Recommendation Report for Planning Permission

REF NO: EG/21/17/PL

LOCATION: Eastergate Water Treatment Works
Fontwell Avenue
Eastergate

PROPOSAL: Application for Variation of condition No.2 following the grant of planning permission EG/22/15/PL relating to colours of building, road layout, landscaping & drainage details. Resubmission of EG/3/16/PL

EASTERGATE
UV REACTOR BUILDING
EXTERNAL VIEWS

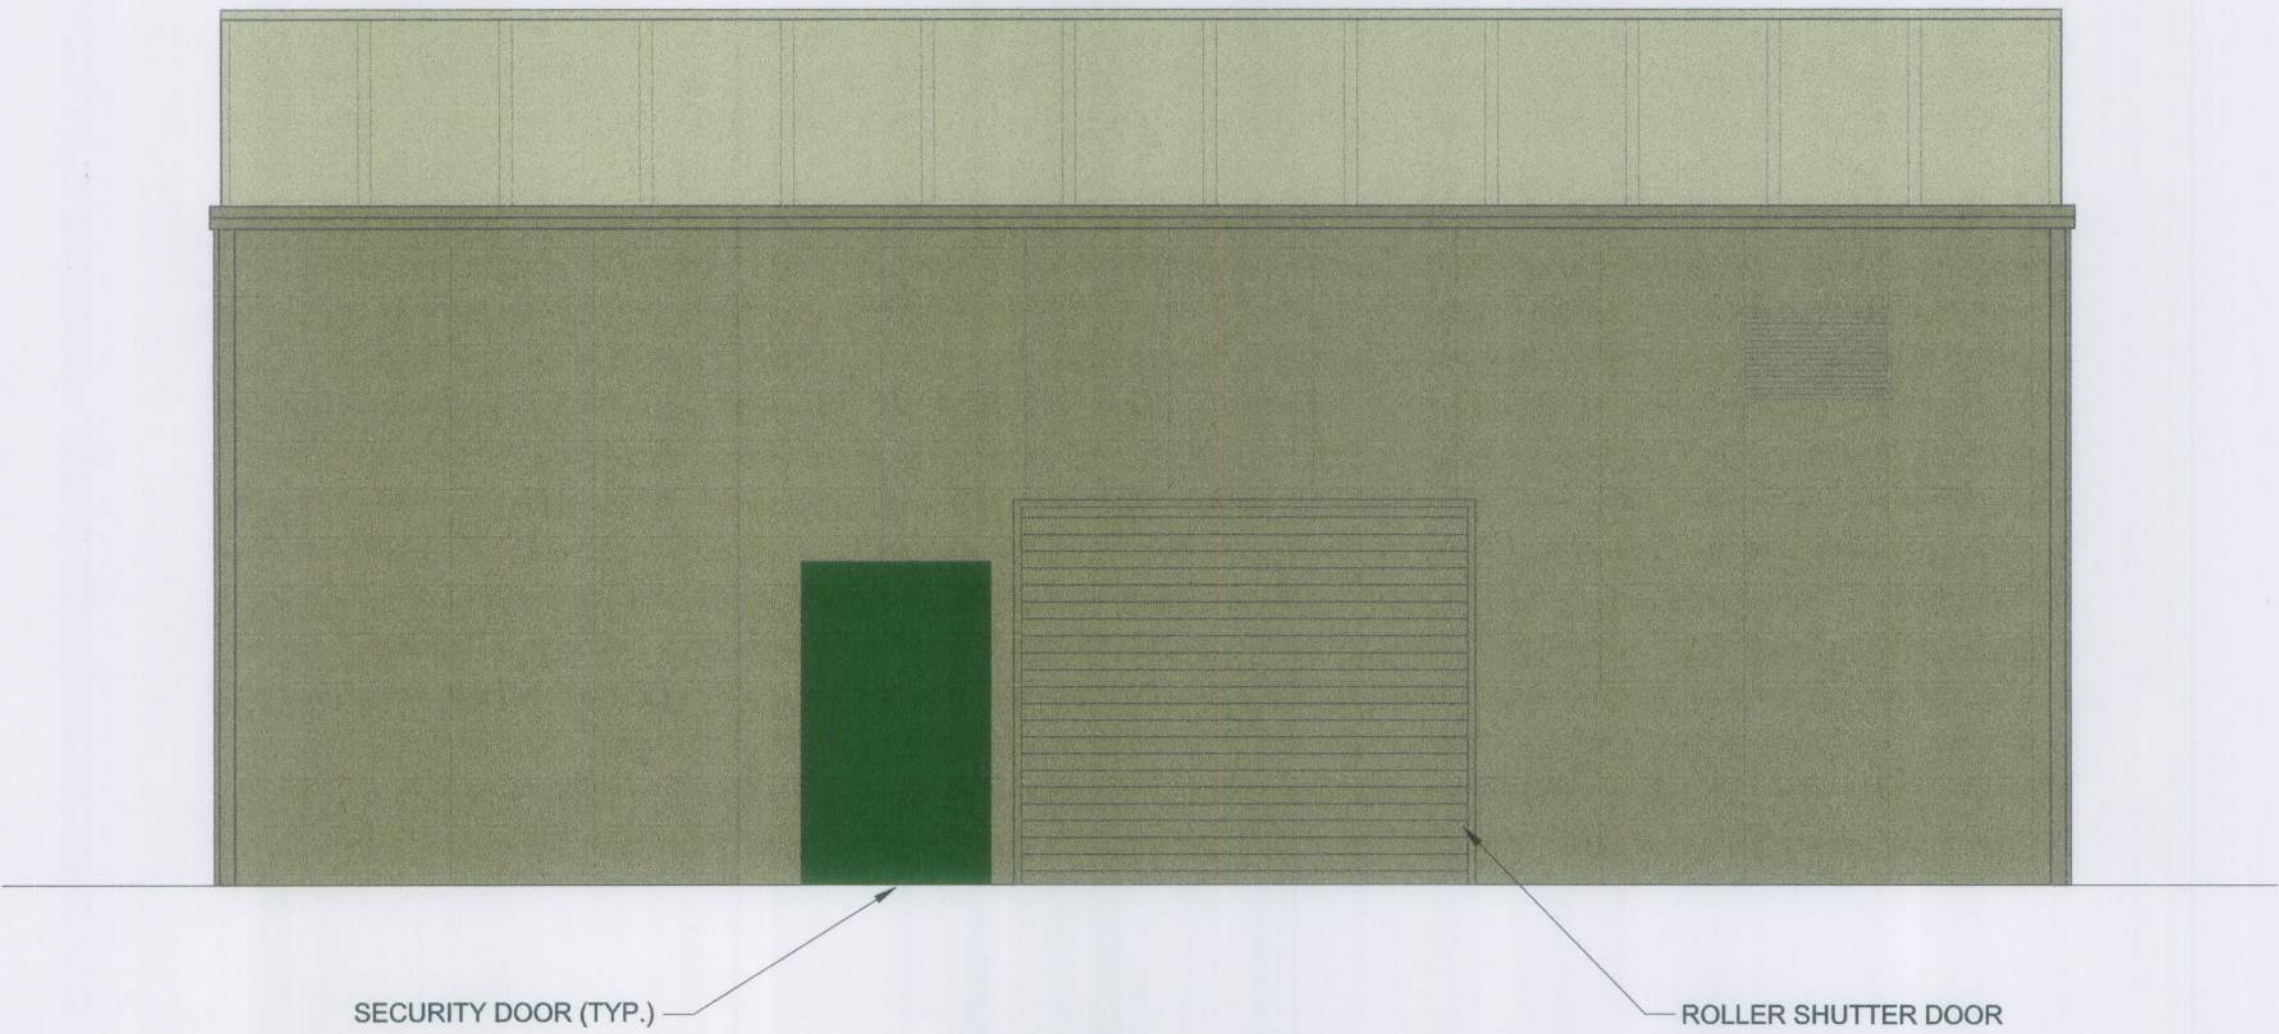
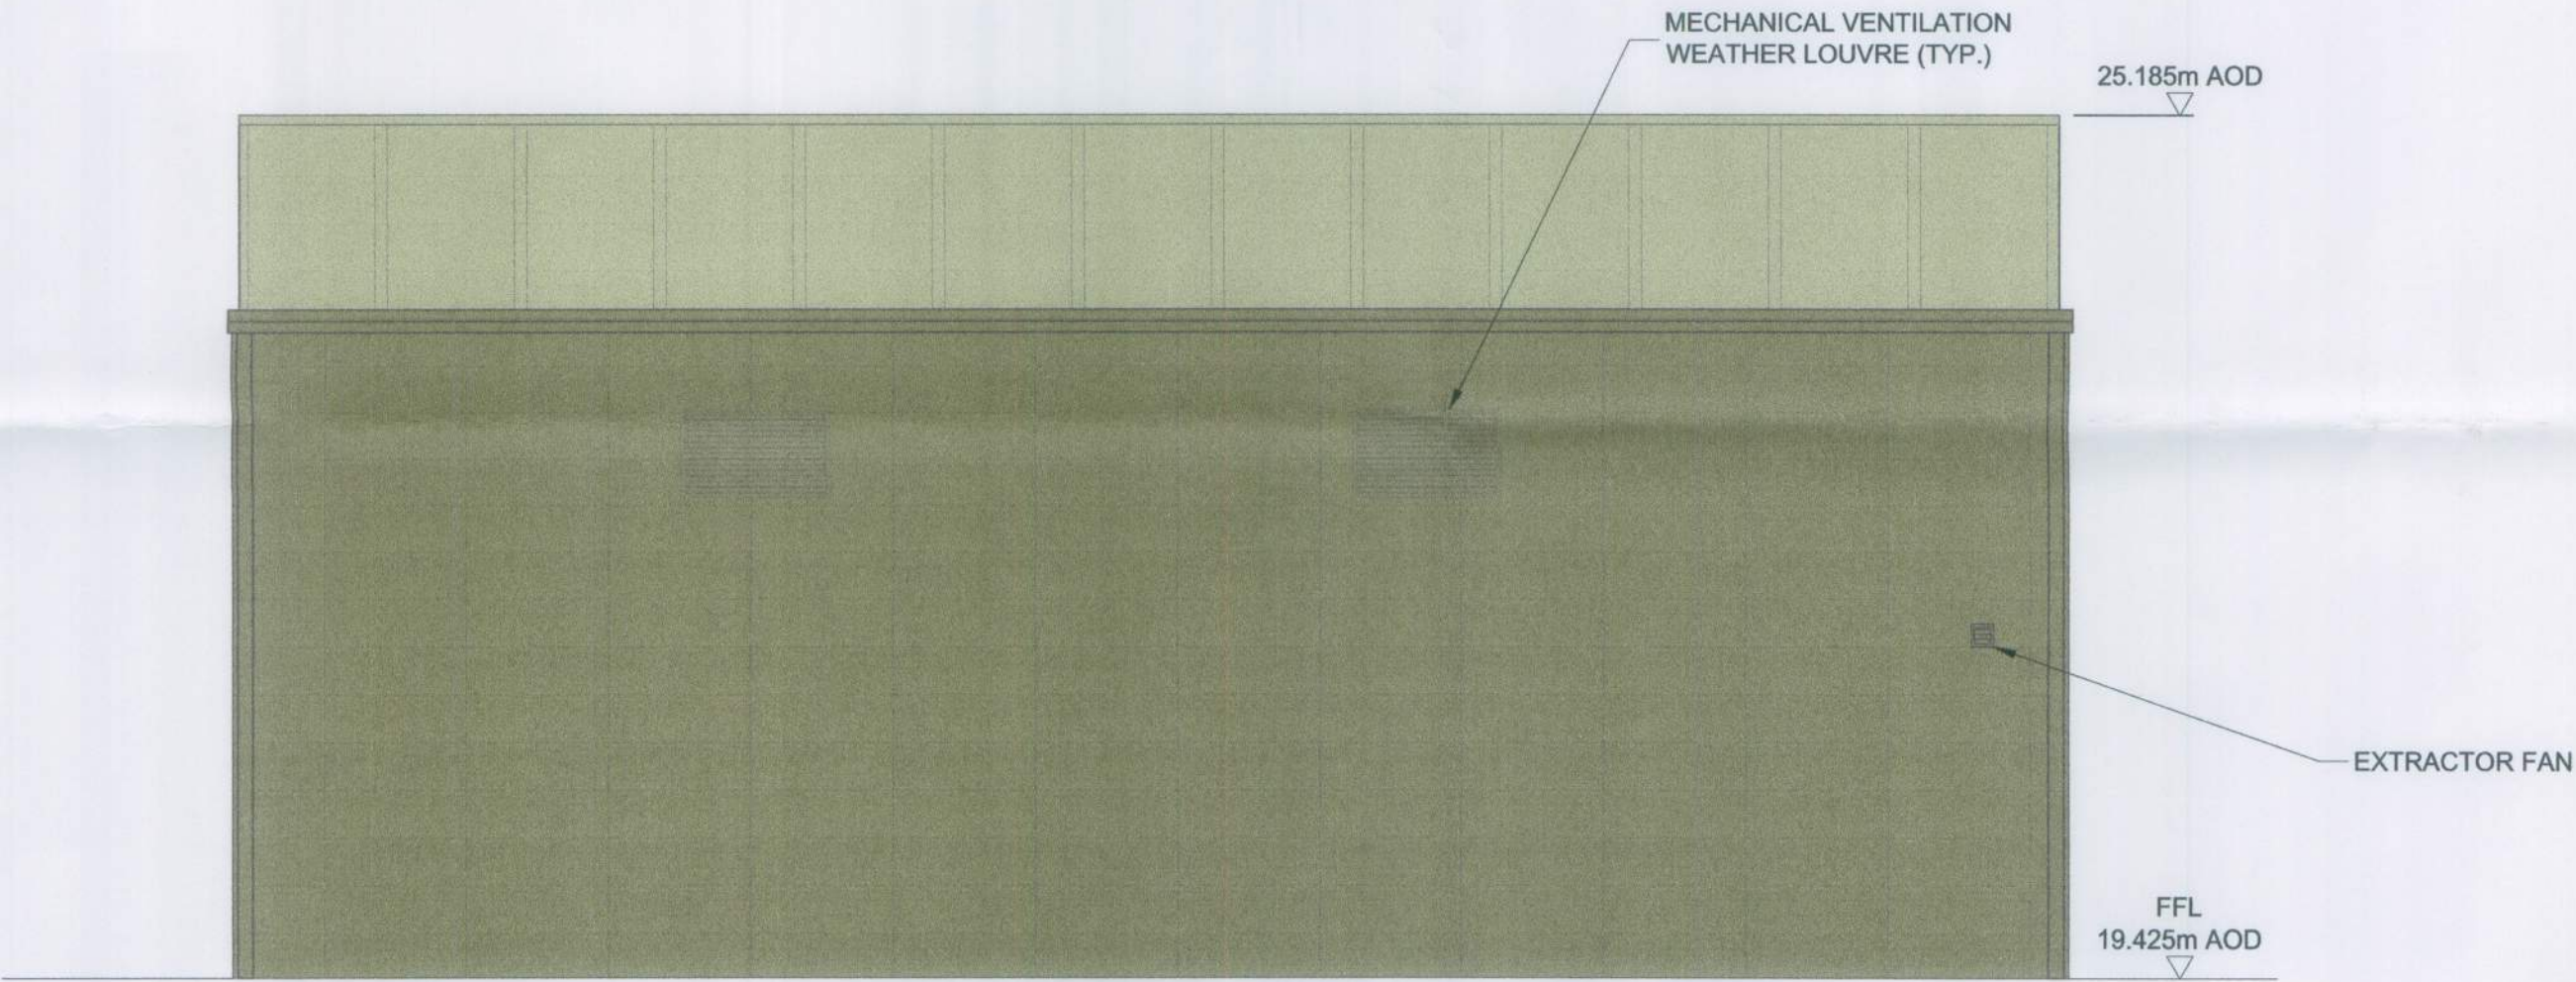
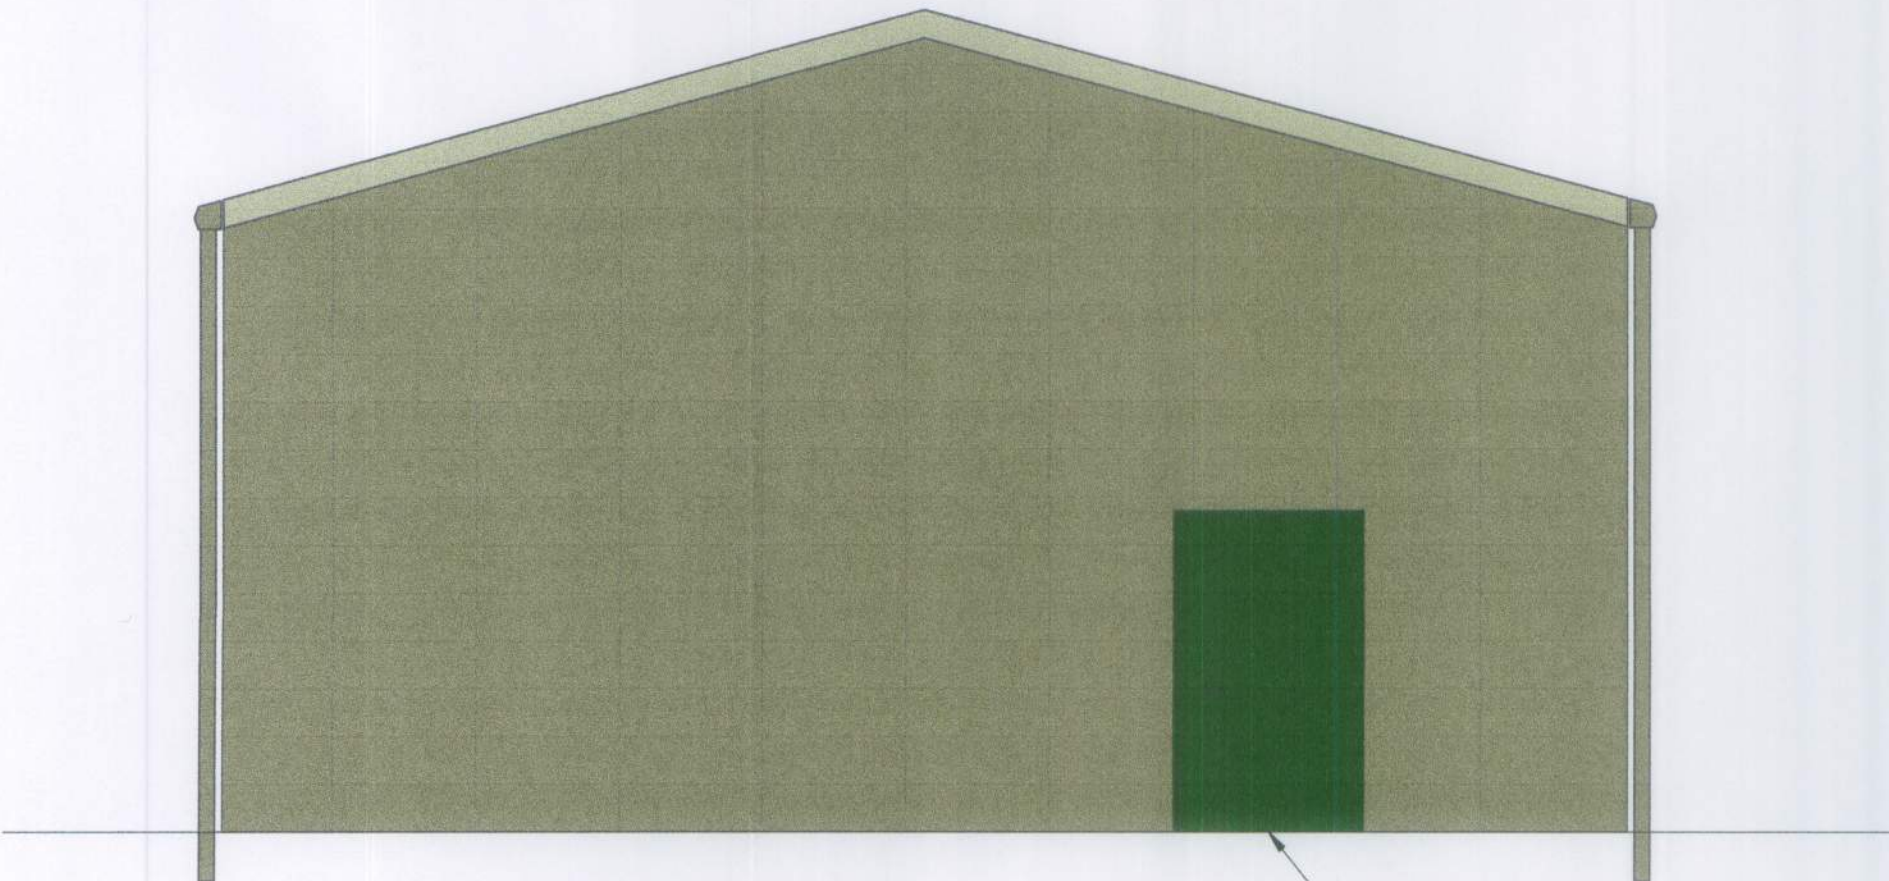
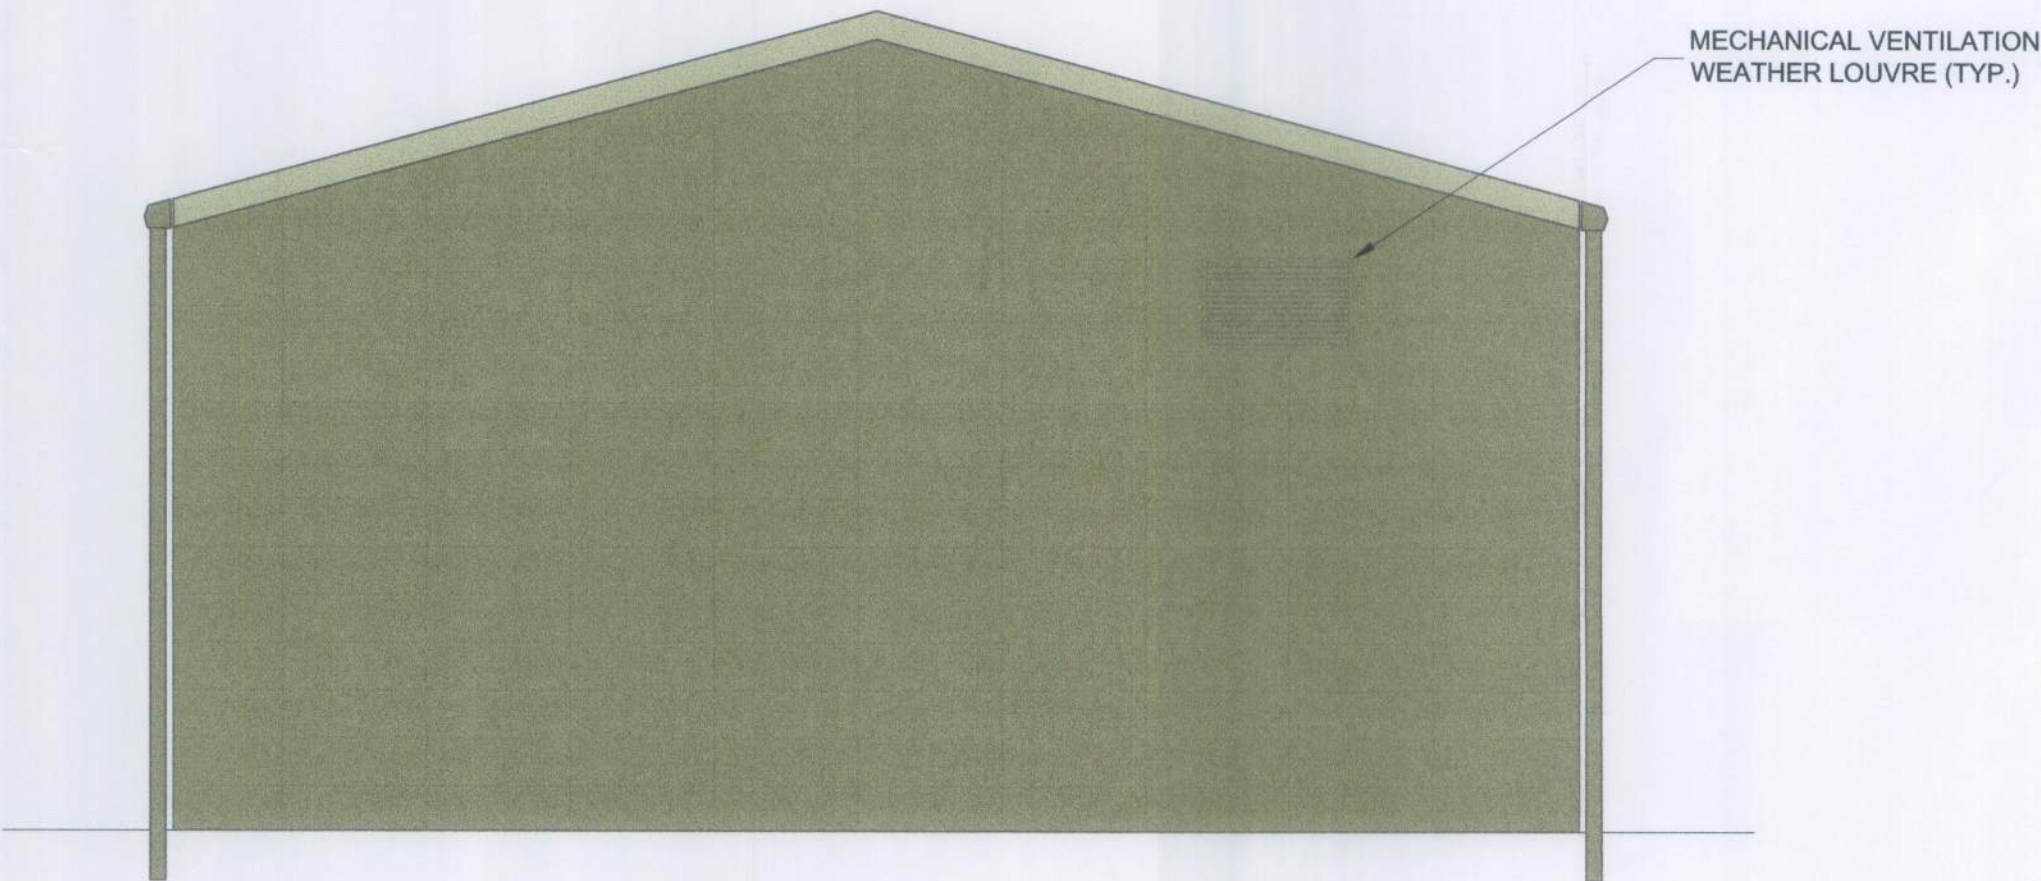
(a) the colour of the proposed UV Treatment building from Olive Green (Walls & Roller Shutters), Goose Grey (Roof) & Dark Blue (Personnel Doors) to Khaki Green (Walls & Roller Shutters), Leaf Green (Personnel Doors) & Willow Green (Roof); and

The building (including the former colour scheme) was previously considered to be coloured appropriately and generally acceptable in the context of the existing site and its water treatment function. It is not considered that the proposed colour change alters the previous determination.
